Fleurie Nursery, Lake Lane, Barnham
Drainage system - Annexe

1a - ADC Drainage Officer Recommendation and requirements

20.6.2022

WA/75/22/DOC

Outfall location (1:500)

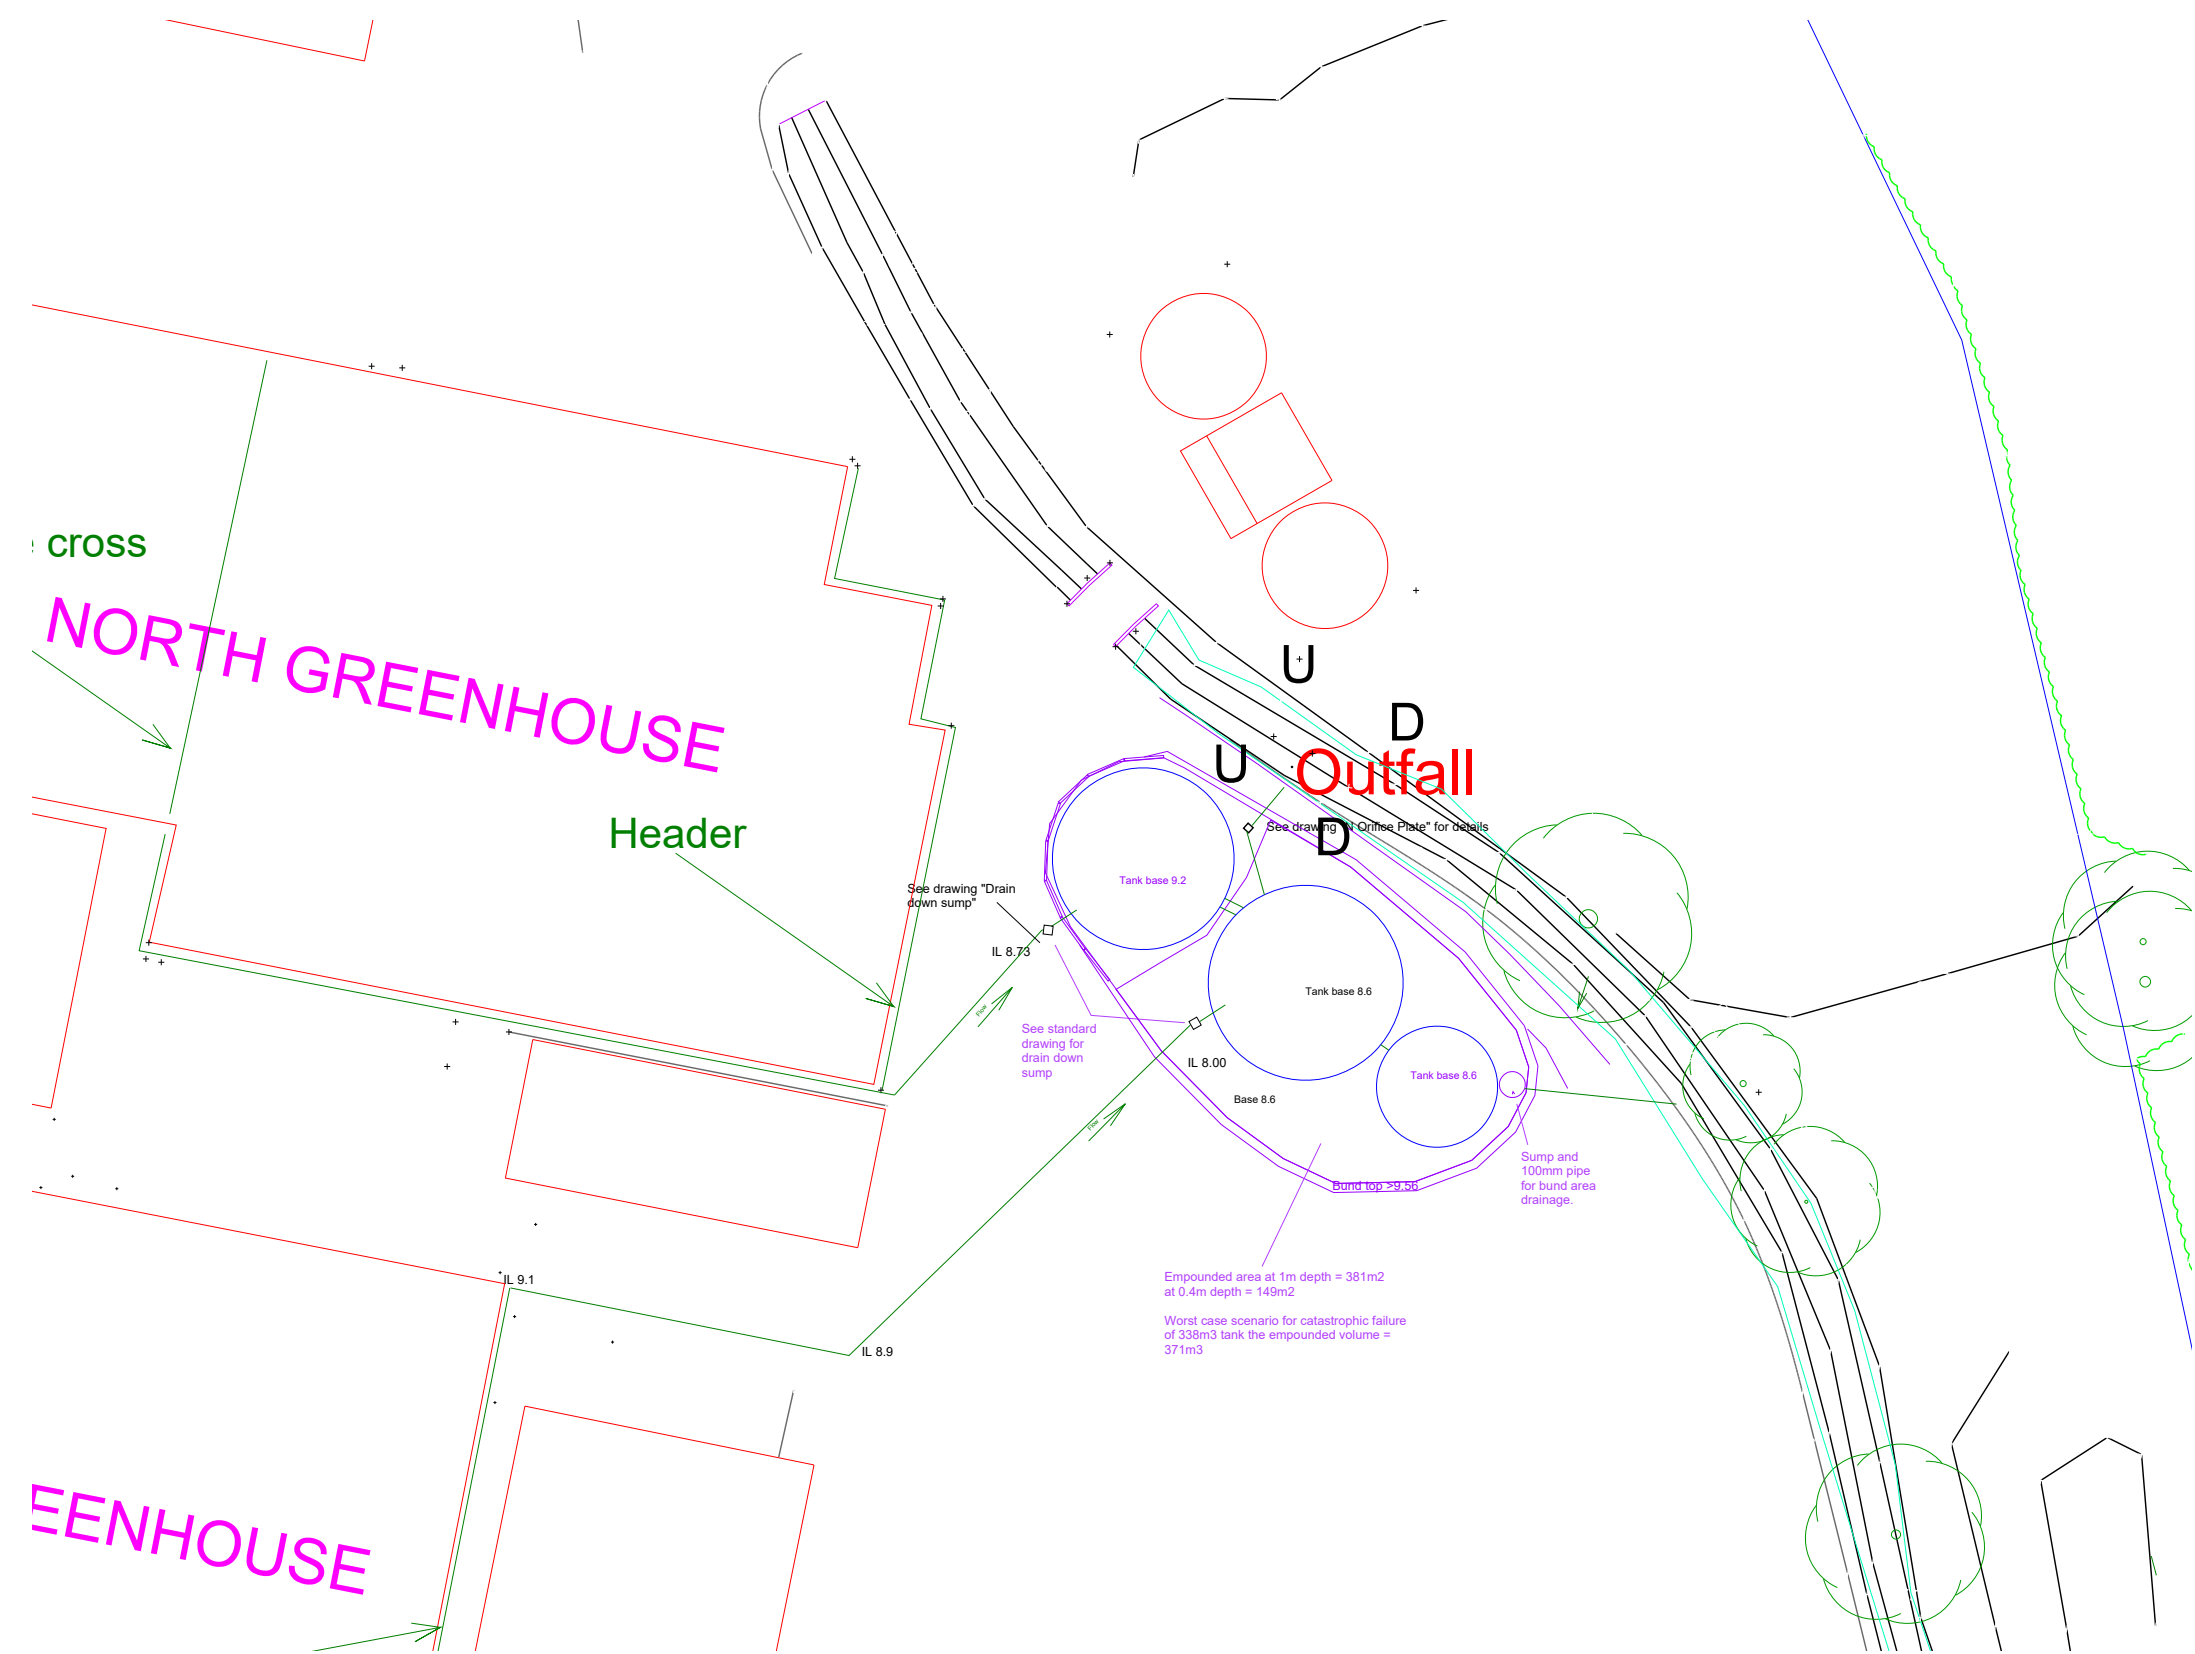
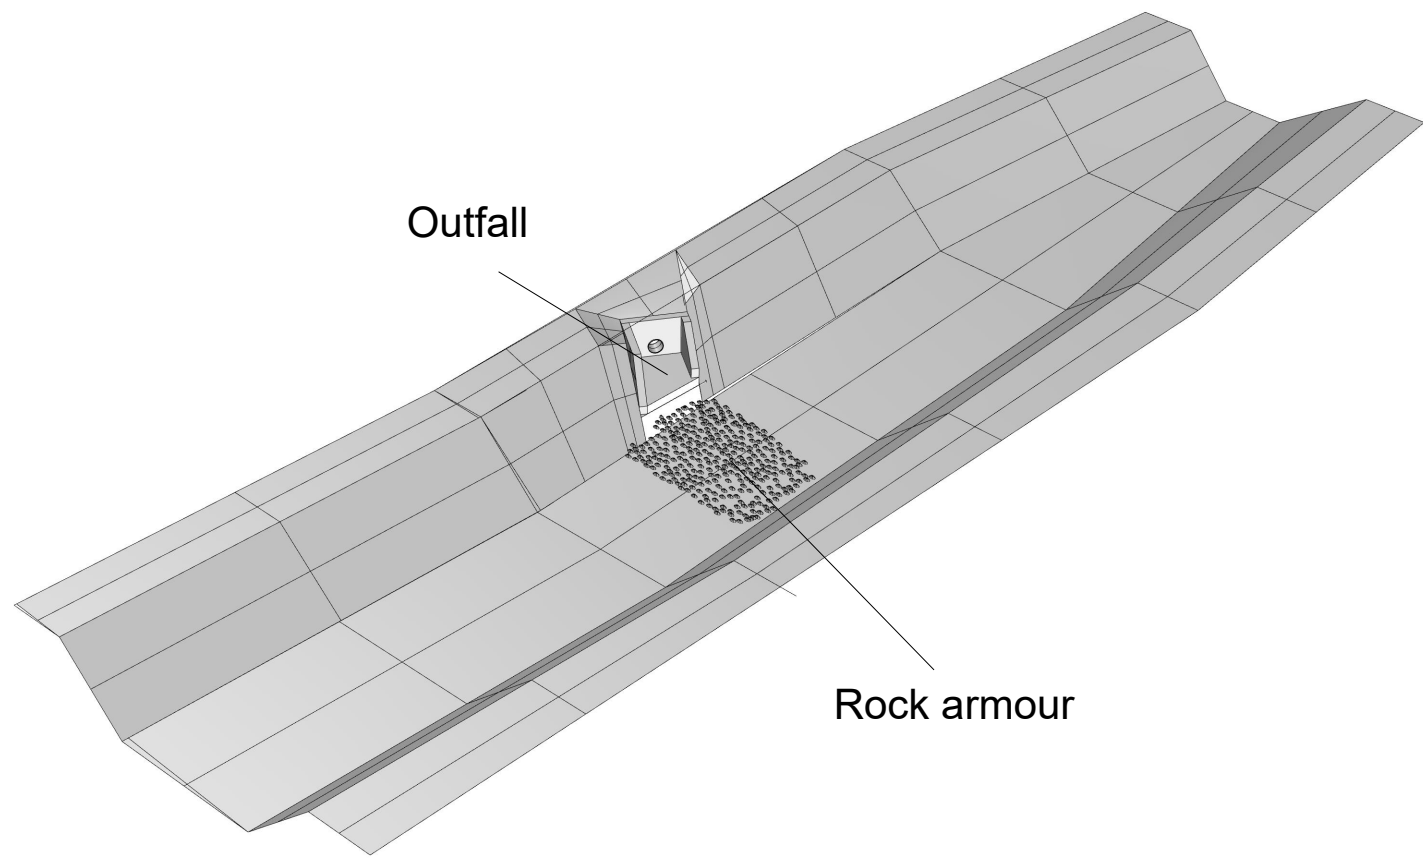
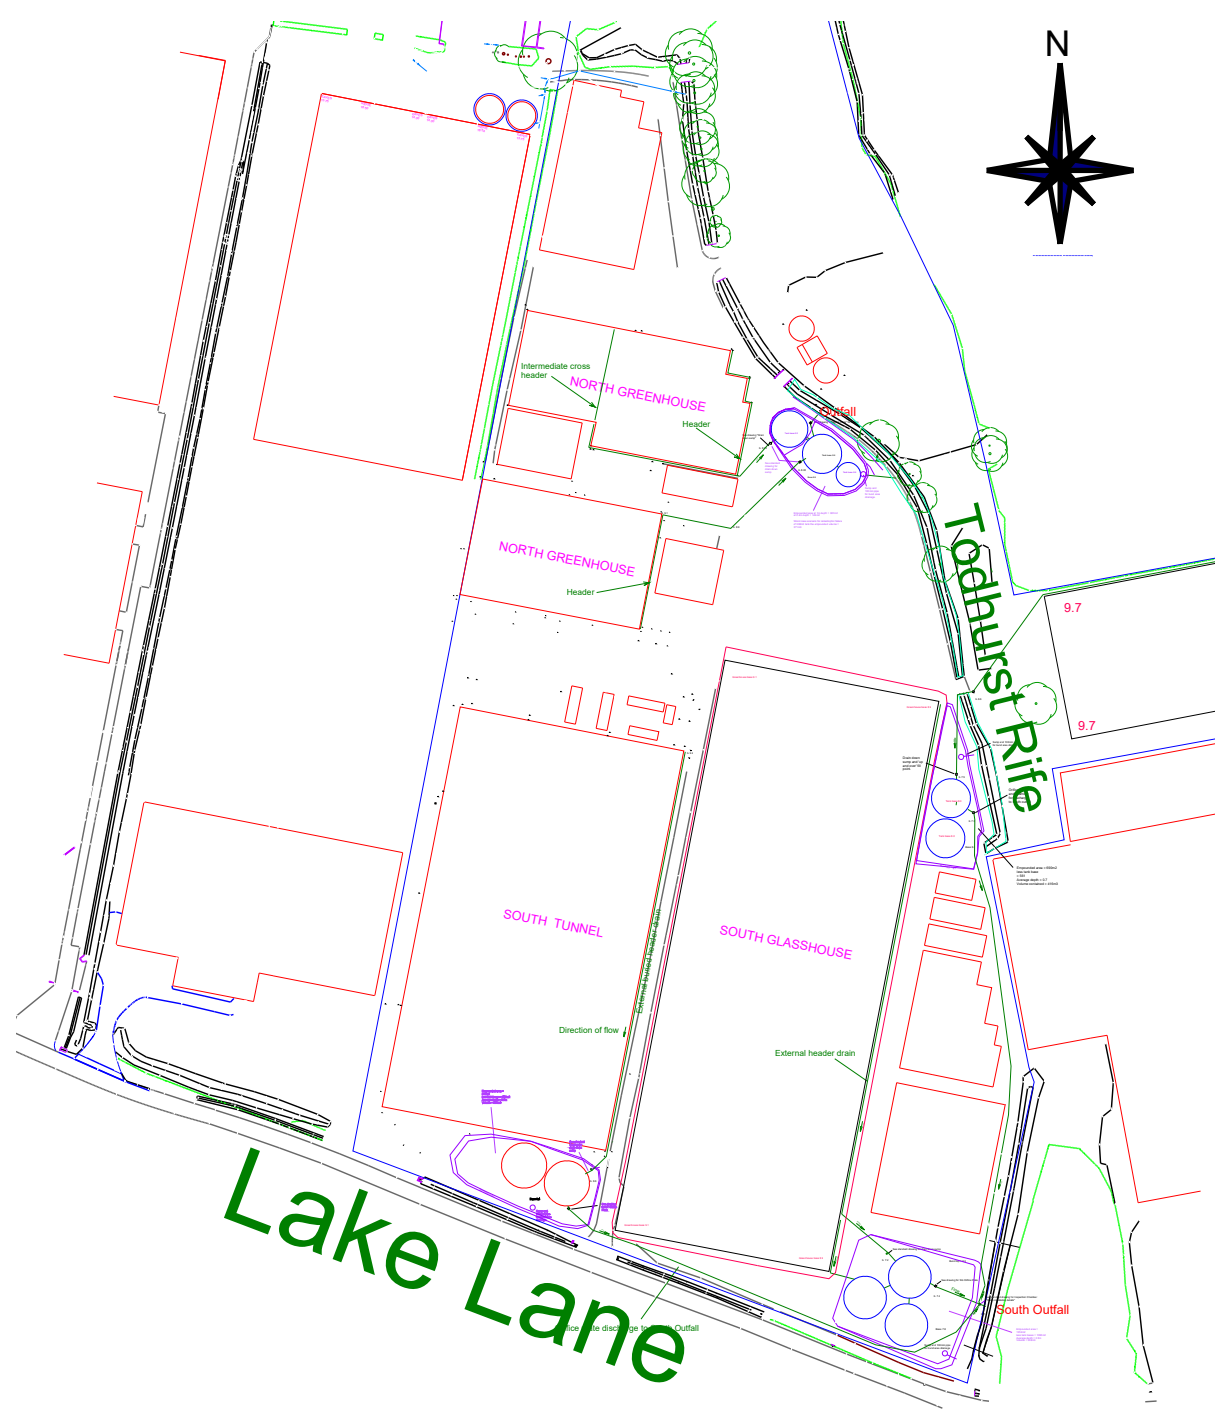
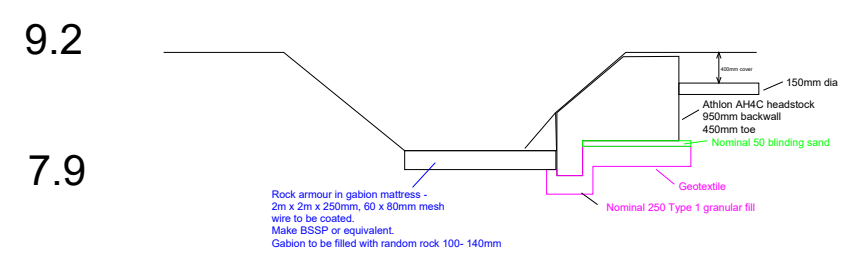
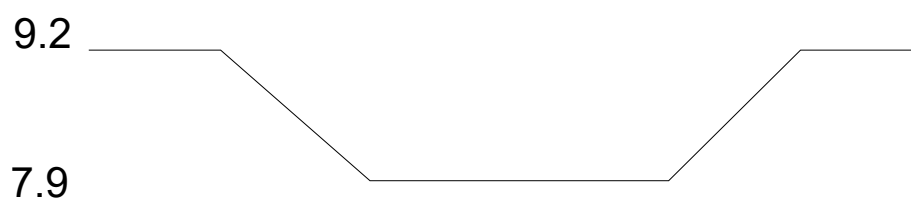
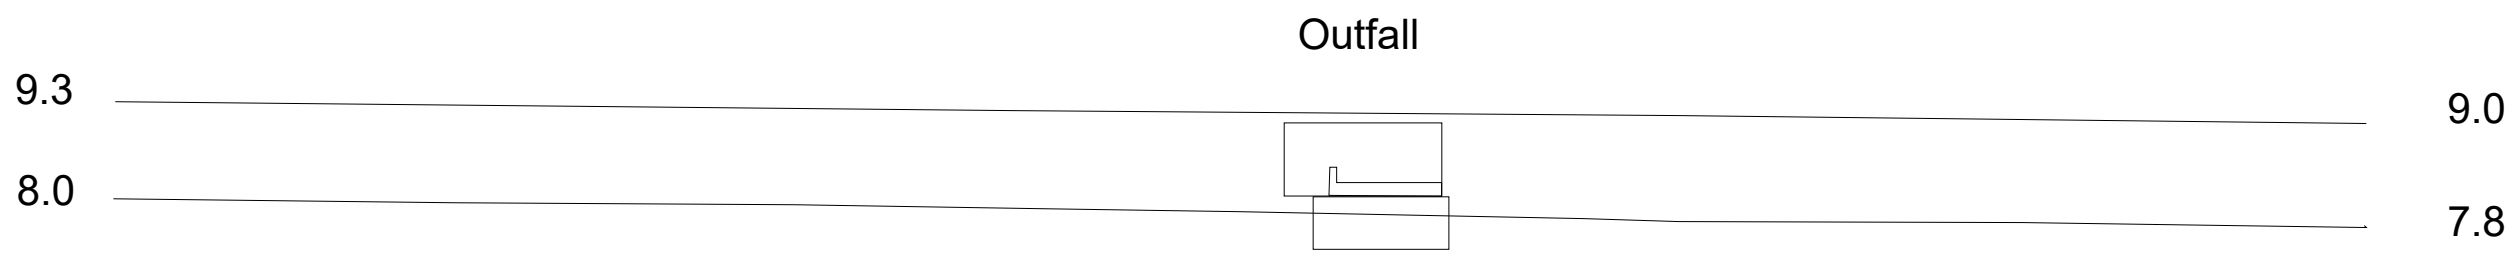
- Drawings of the outfall from the tanks must be provided, this should include a cross section / long section showing the tank in relation to the sump pump (for drain down) and the flow control devices (orifice plates), and outfall. It is currently unclear how the orifice plates relate to the sump / pump system and thus there is uncertainty whether the pumped runoff could enter the ditch during an extreme rainfall event.
- The proposed orifice diameters are (in some cases) smaller than 50mm. The applicant should provide details to demonstrate how silt and other materials, that could block the outfalls, will be prevented from entering the storage tank.
- Ground levels, invert levels, and cover levels must be provided on the drainage drawings.
- Technical drawings for the outfall(s) must be provided.

6) A flap valve on the outfall(s) must be provided (to prevent backflow of water from the ditch network(s) entering the drainage system)

- It appears from the photographs included with the application, that an outfall has been constructed in contravention of the Land Drainage Act 1991. The applicant should be aware that Land Drainage Consent is required prior to outfalls being constructed and cannot be issued retrospectively. Drawings of the constructed outfall must be provided so that our Land Drainage Consent (LDC) team can review these and ensure there are no issues with the design. Furthermore, the LDC team may request an onsite meeting or inspection to review the unconsented outfall and any works in and around the existing ditches.
